4 September 2019

RE: HAMMONDCARE GREENWICH HOSPITAL REDEVELOPMENT

WGE has performed a structural due diligence exercise on HammondCare's Greenwich Hospital site, which is due to be redeveloped into a mixed use village comprising of health, aged care and retirement living. The current site consists of an existing hospital which is due to be demolished via a staged approach.

1 CROSS SECTION - HOSPITAL & PALLISTER
1:250

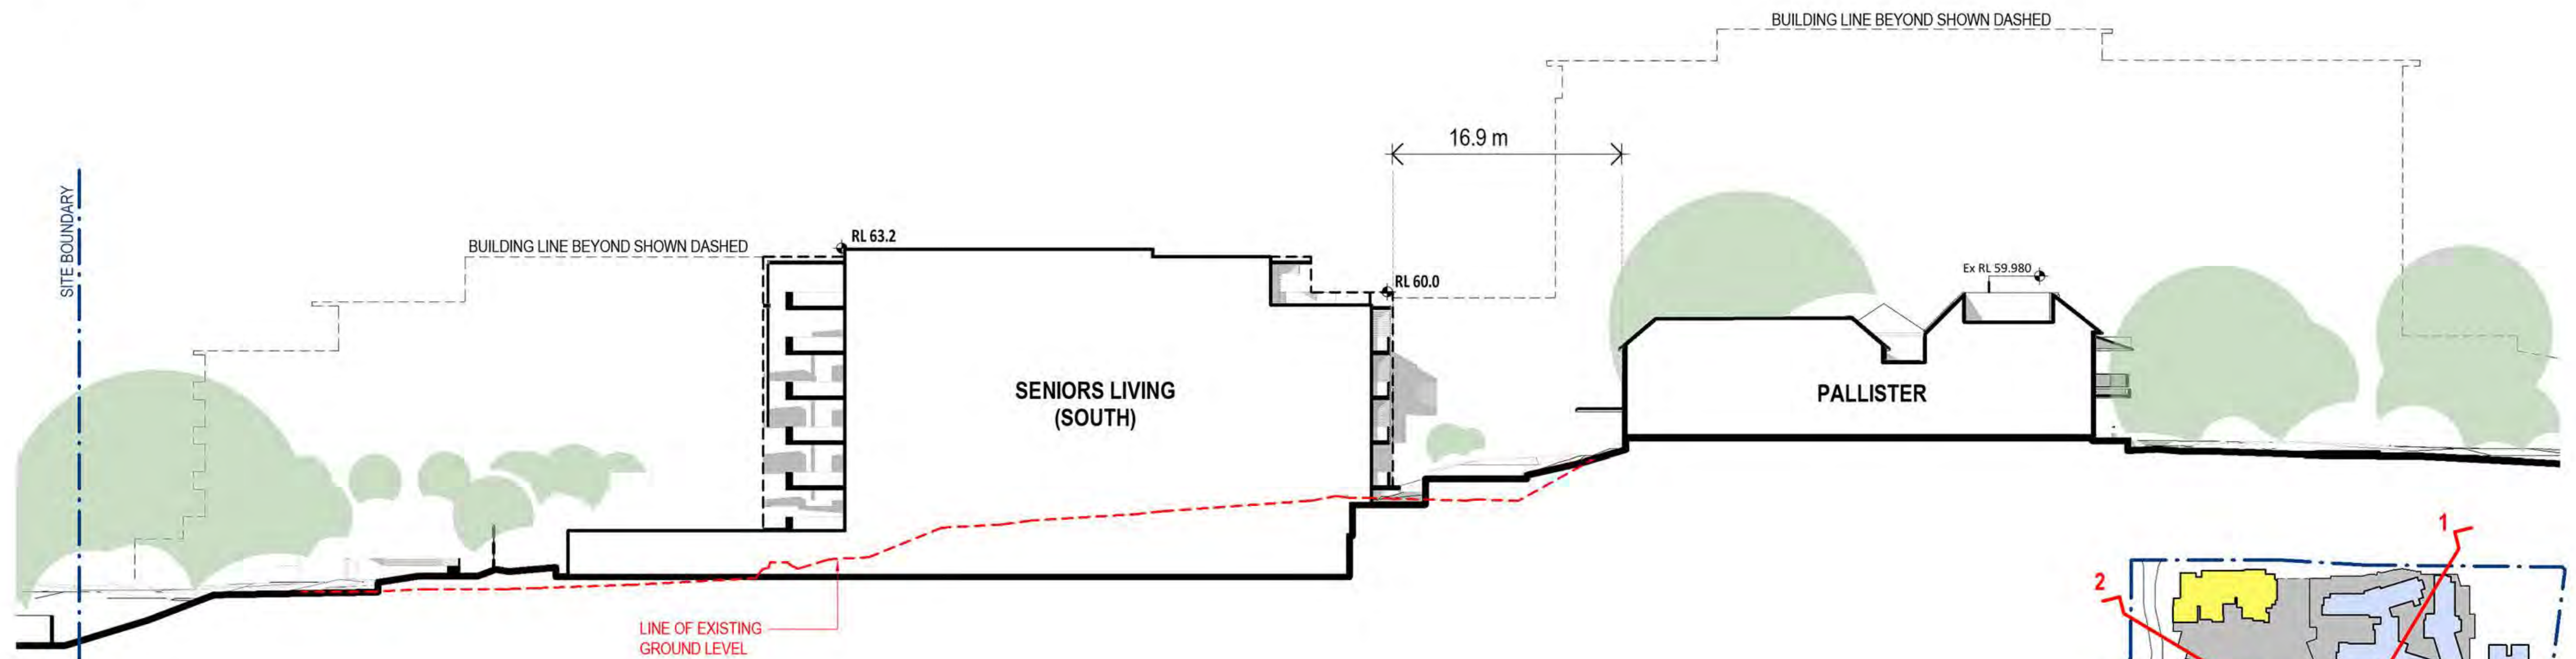
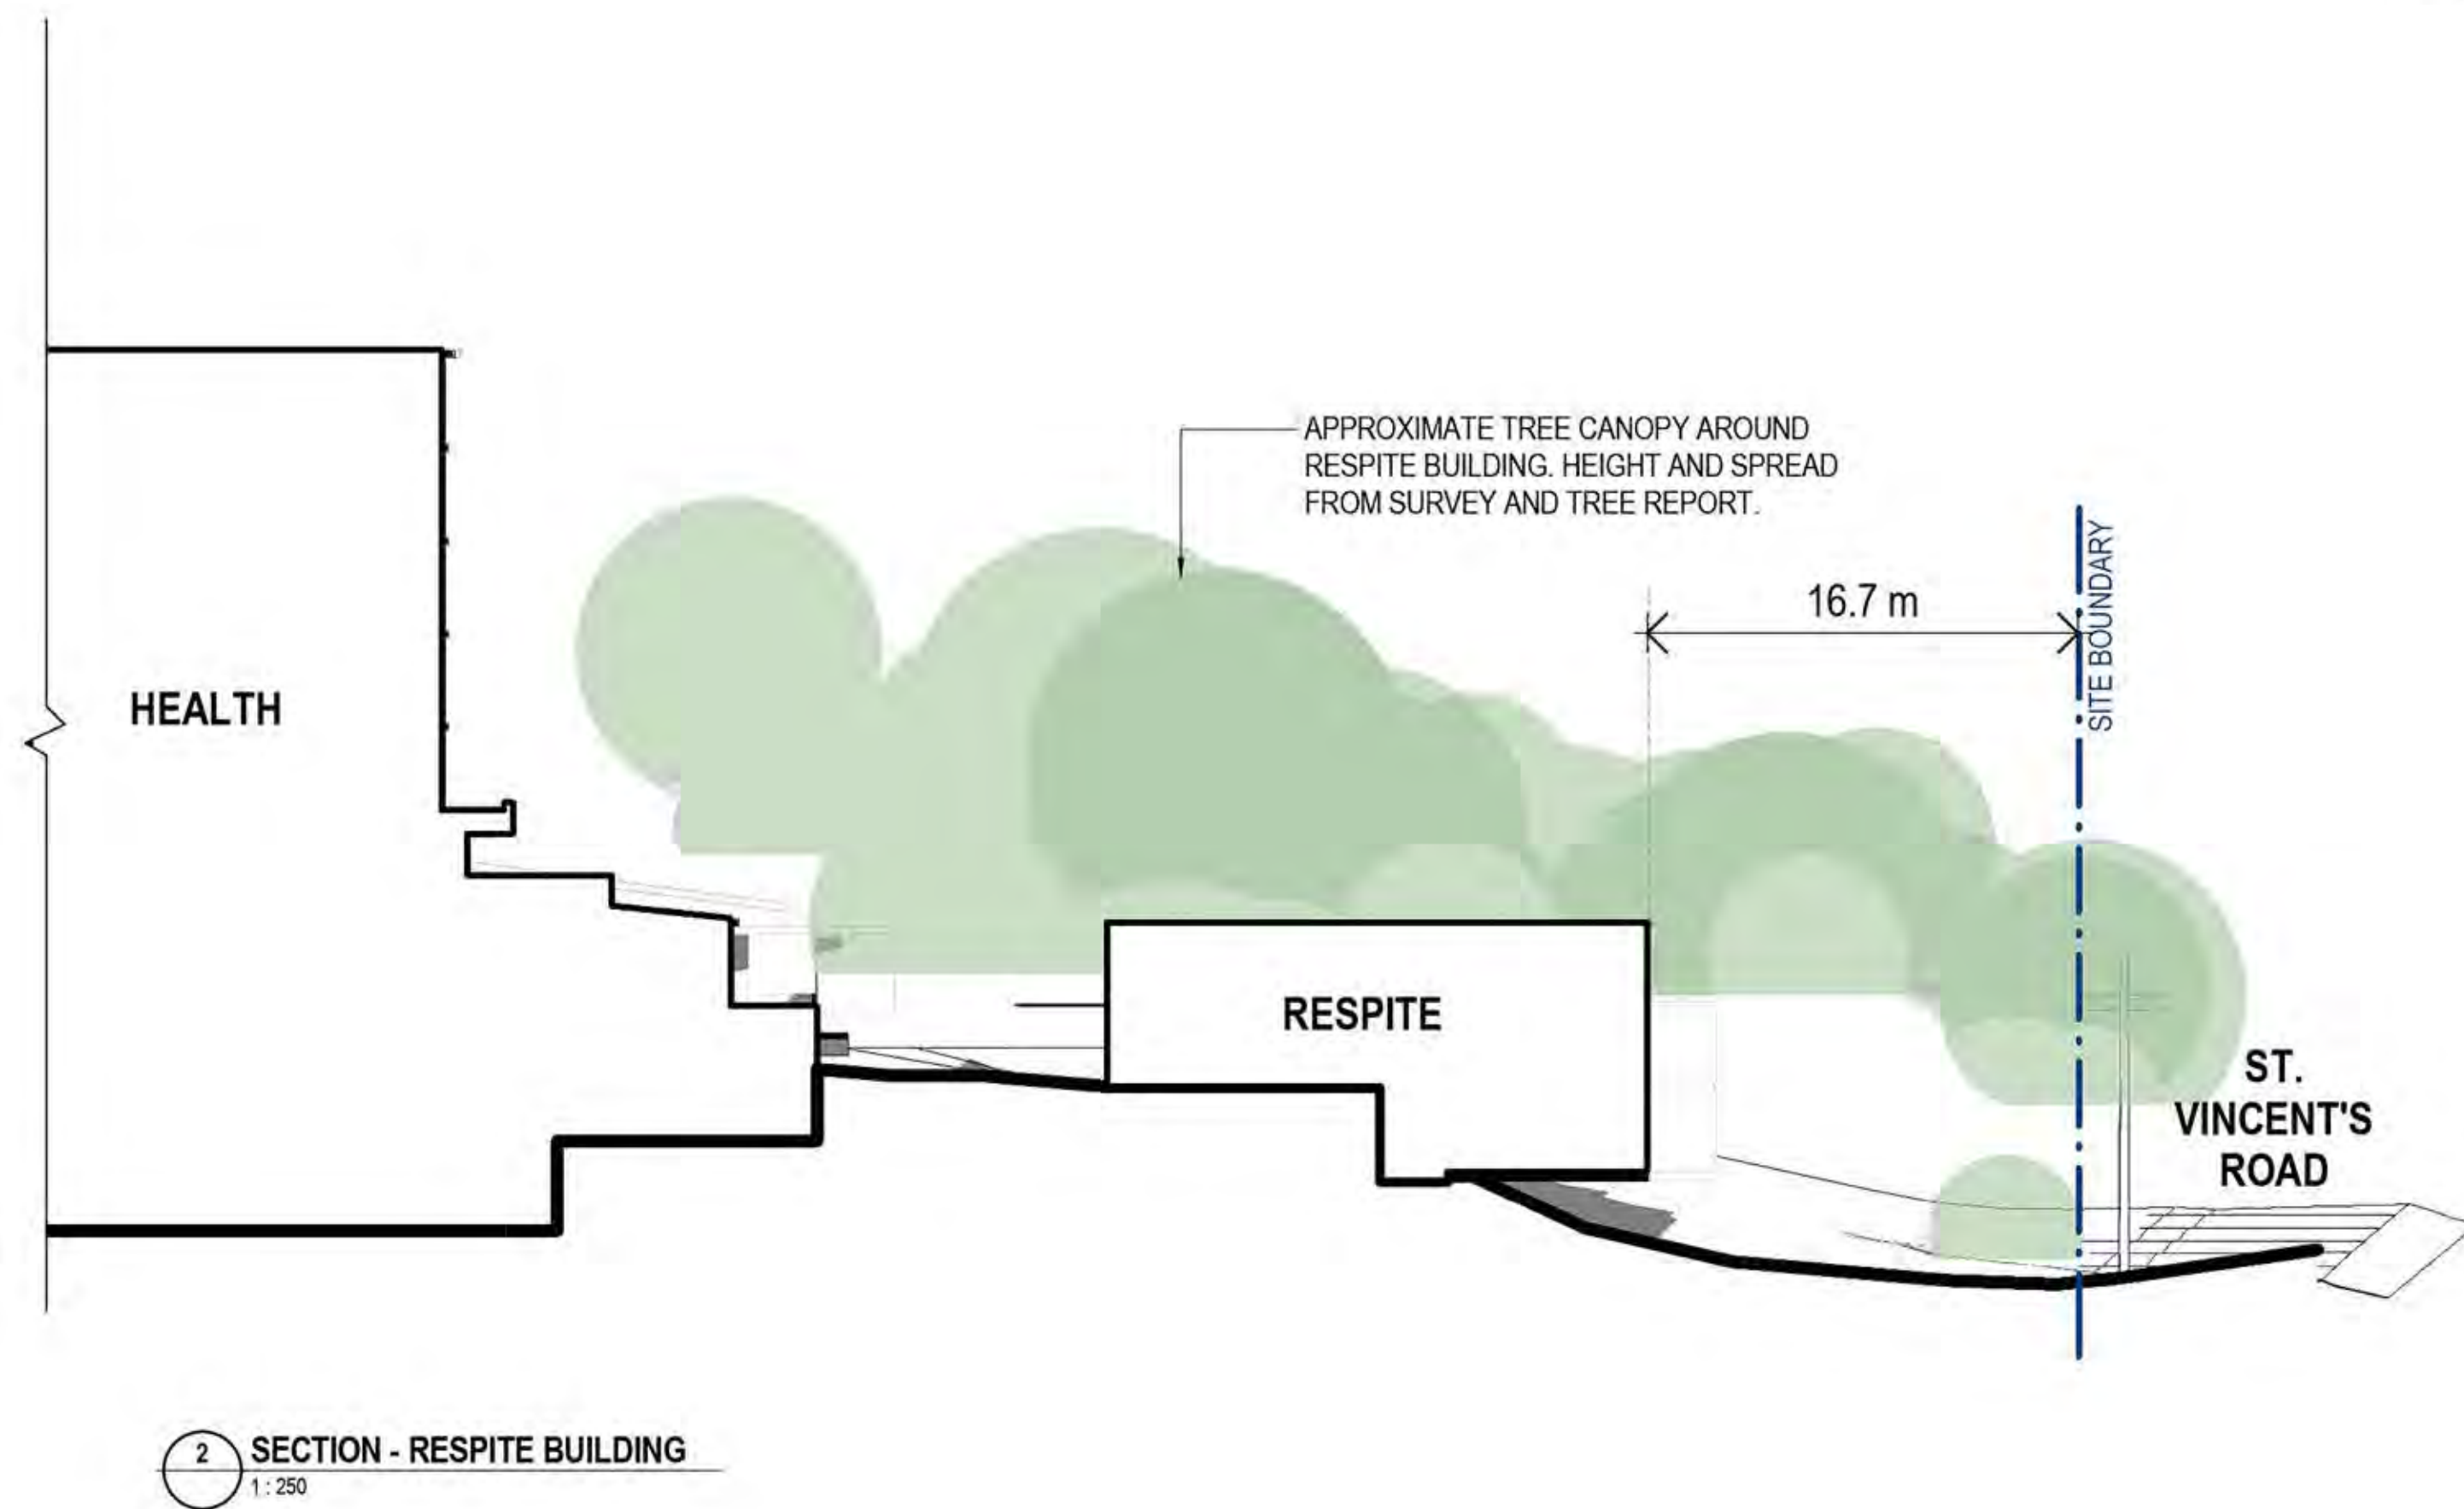
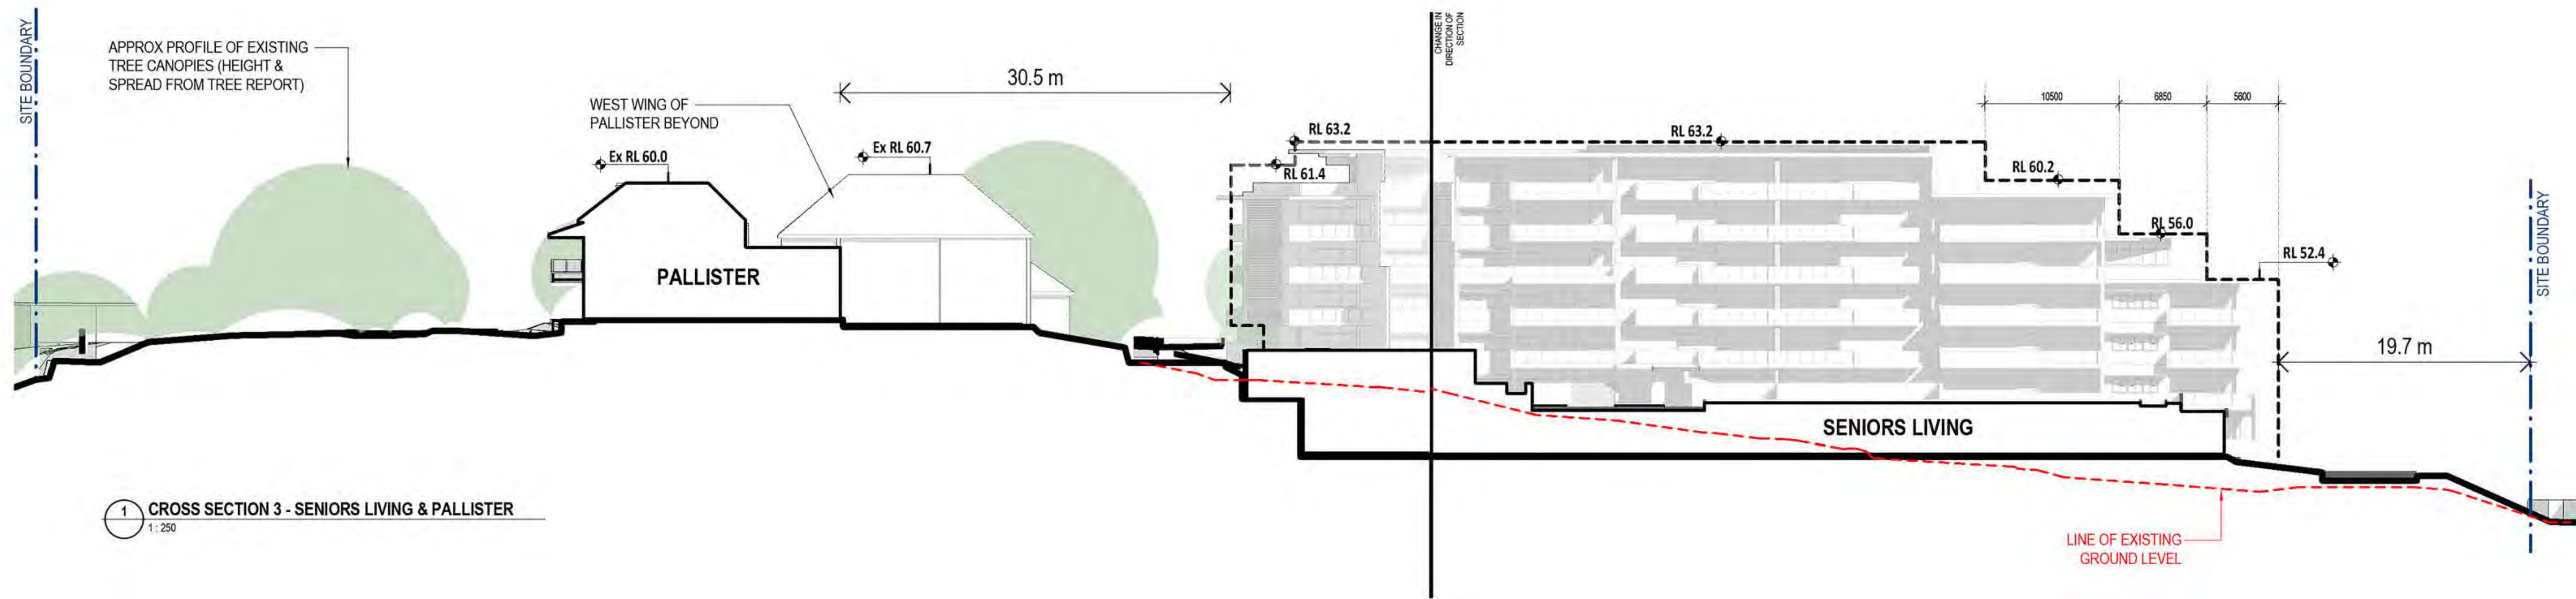
From the site section drawing provided by the architects, Bickerton Masters, the Pallister building is approximately 30m away from the proposed new hospital's basement and 19m away from the excavation extent of the seniors living building.

From the approximate zones of influence, based on a 1:1 slope with respect to the excavation, there is sufficient clearance to the Pallister building to not have an adverse structural impact on the heritage structure.

However, we note that the site is underlain by sandstone at depths close to the surface. Hence, excavation into rock is to be anticipated, during which appropriate measures for noise and vibration control should be undertaken.
